Application number: 2026/90111	
What is the application for?:	Erection of first floor rear extension and alterations to fenestration
Address of the site or building:	18, George Avenue, Birkby, Huddersfield, HD2 2BJ
Postcode:	HD2 2BJ

Type of comment: An objection	
Do you wish your comments to be published on the website anonymously?	No

PROPOSED REAR ELEVATION Scale 1:100

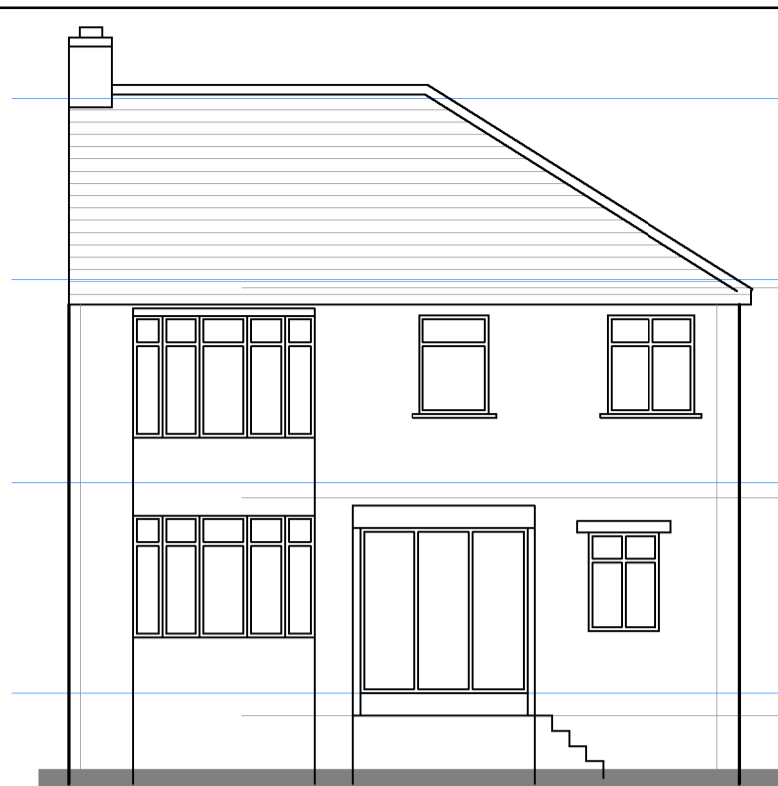
Although part of the proposed extension appears to be slightly set back on the right-hand side of the rear elevation, the overall design still results in a substantial two-storey built form at the rear which will be highly visible from my property. From my upstairs bedroom window, I will be looking directly towards the side elevation of the new two-storey extension, which will significantly change the current open aspect and will create a more enclosed and overbearing feel.

In addition, I feel the proposed design is not in keeping with other extensions in our row of houses. To my knowledge, no other neighbouring property has extended the entire upper floor forward to align with the existing rear ground floor projection. While part of the first-floor extension is shown set back (on the side adjacent to my property), the overall proposal still creates a much larger and more dominant form than what is typical for neighbouring properties and therefore appears out of character with the established pattern of development.
